Addendum No. 2

RE: Contract ID C203921

Johnston County (R-5769)

Novo Nordisk Access Road From SR-1913 (Gordon Road) To
Proposed Novo Nordisk Site

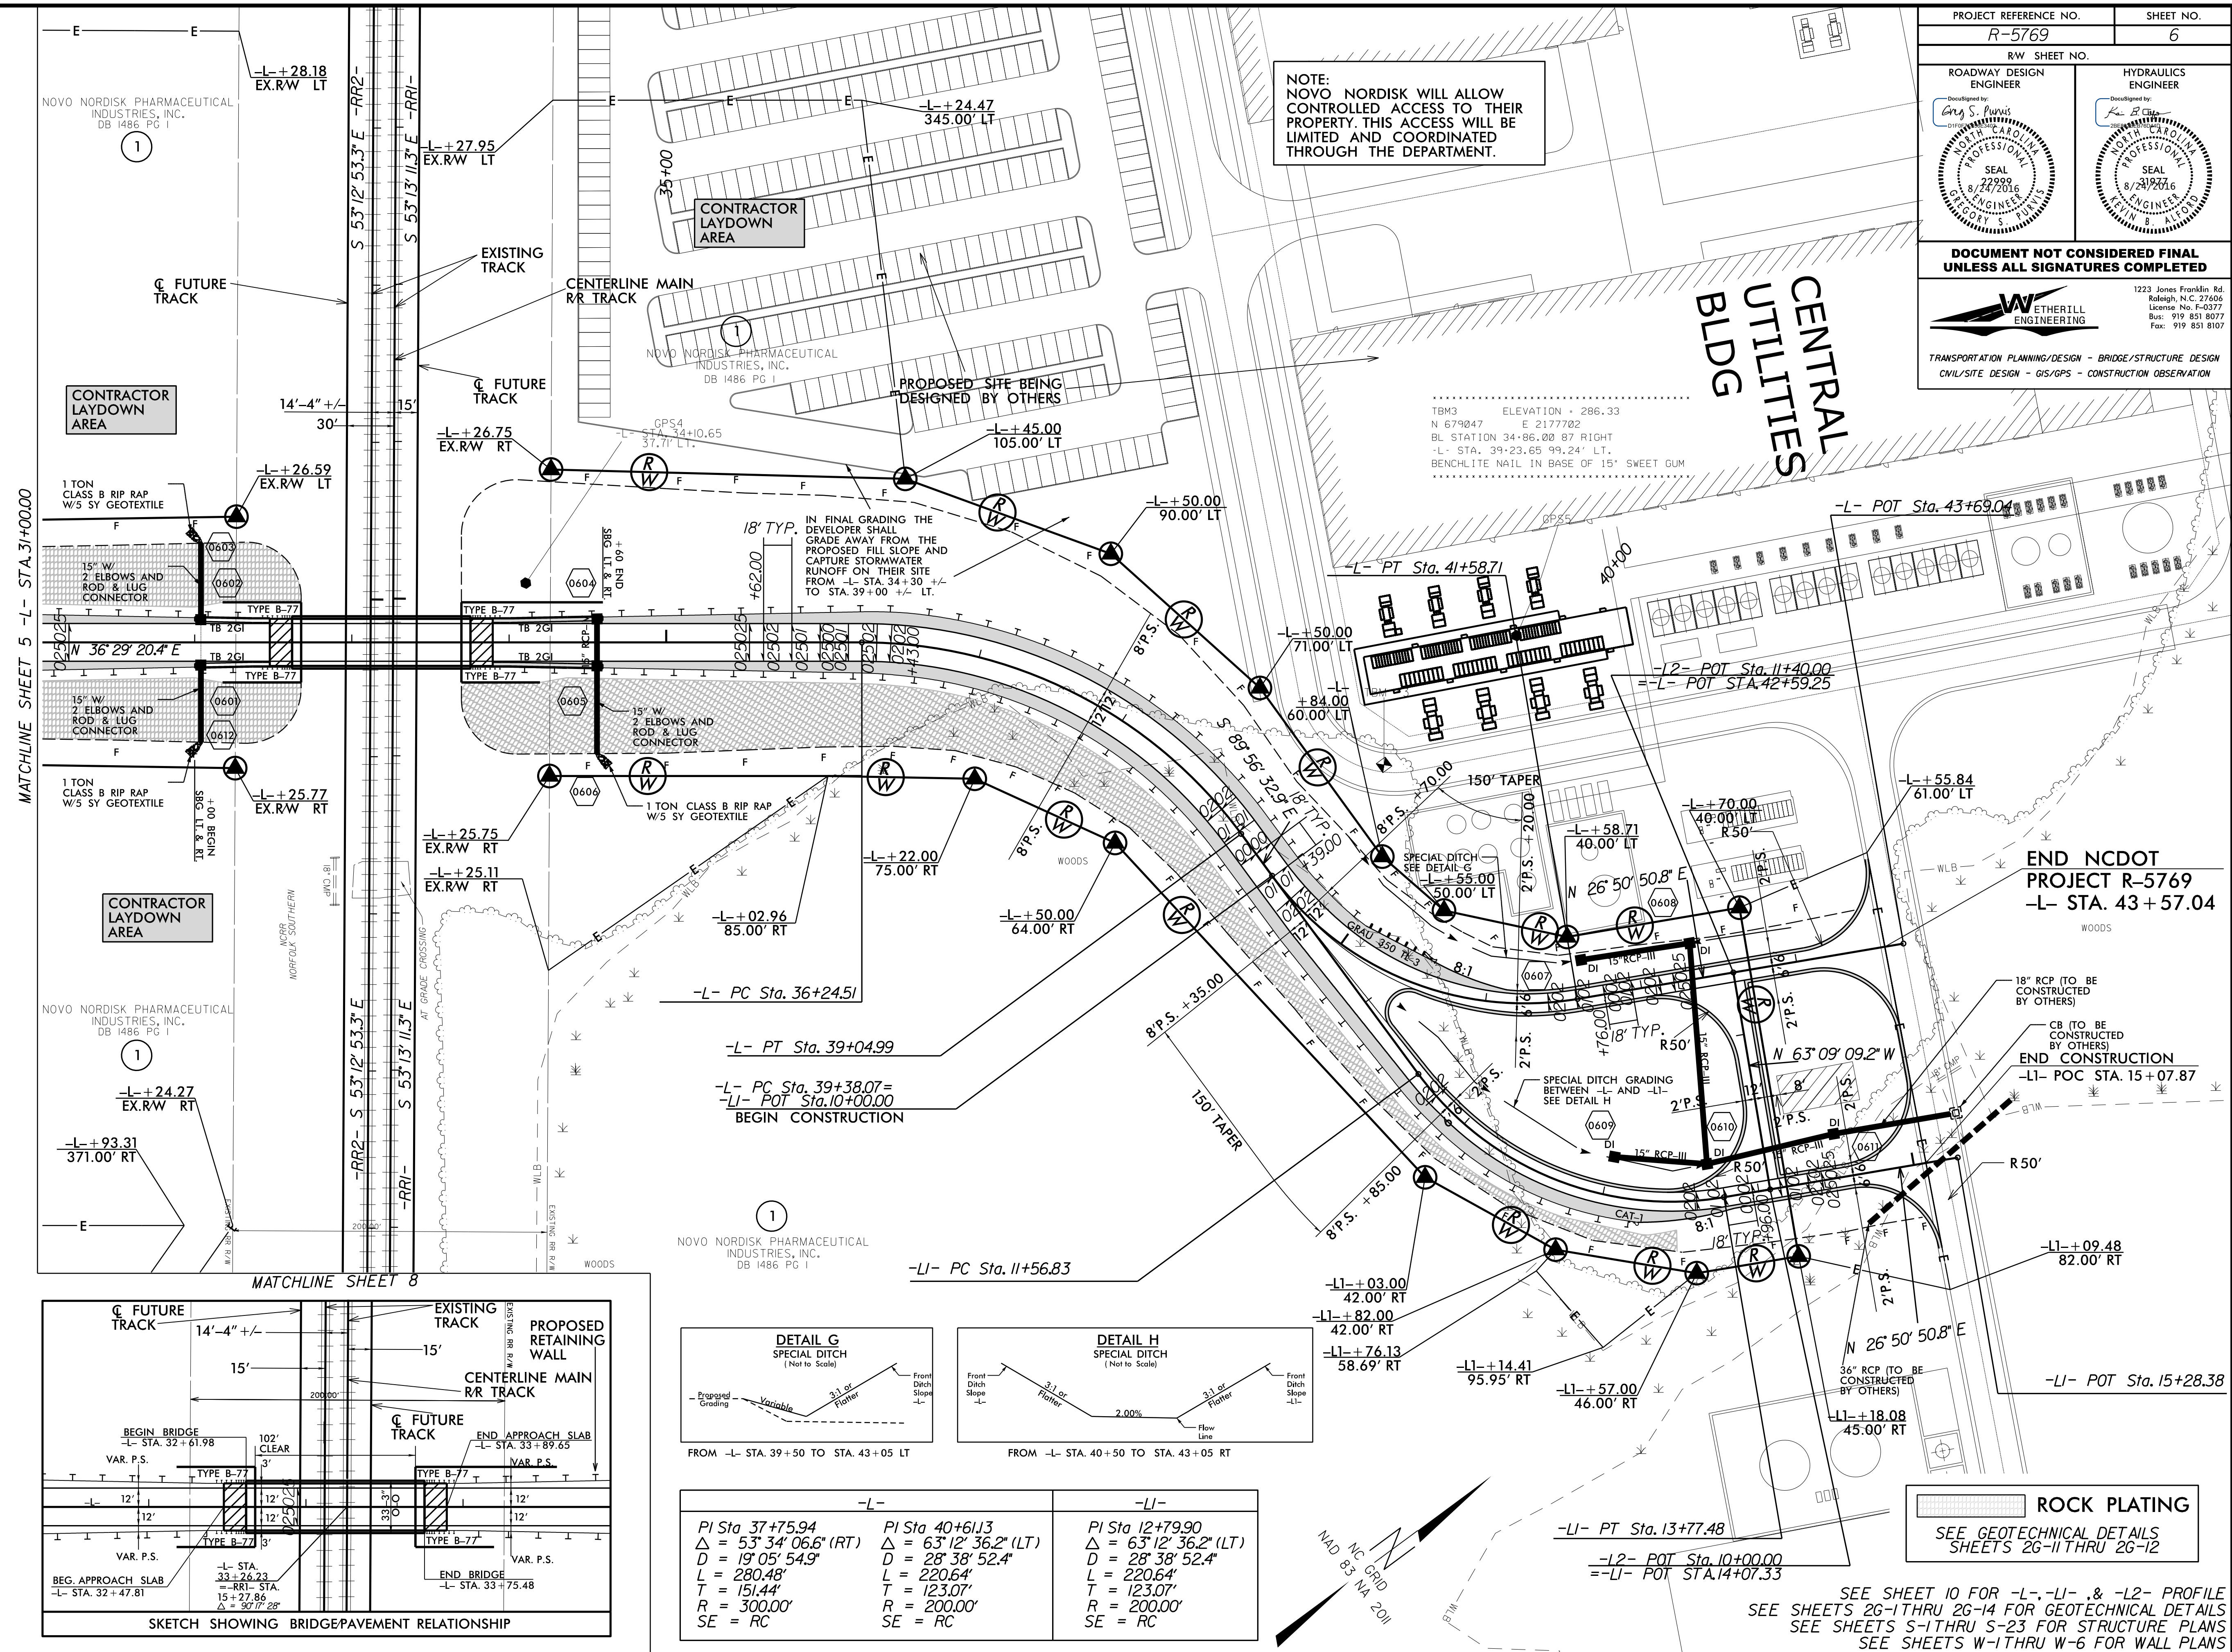
Page No.	Revisions
Proposal Cover	Note added that reads "Includes Addendum No. 2 Dated 10-14-2016".
G-33	Revised the project special provision entitled "NOTES TO CONTRACTOR" to add notice of removal of Railroad crossing.

- 1) Novo Nordisk will allow controlled access to their property. This access will be limited and coordinated through the Department.
- 2) Contractor will be required to follow NCDOT reclamation procedures for borrow/waste staging areas for construction if land disturbing activities occur within the Contractor laydown areas.
- 3) Contractor shall maintain access to all Church services for the New Bethel Baptist Church.
- 4) The Railroad crossing just to the south of the proposed bridge on Plan Sheet 6 has been removed and is no longer useable.
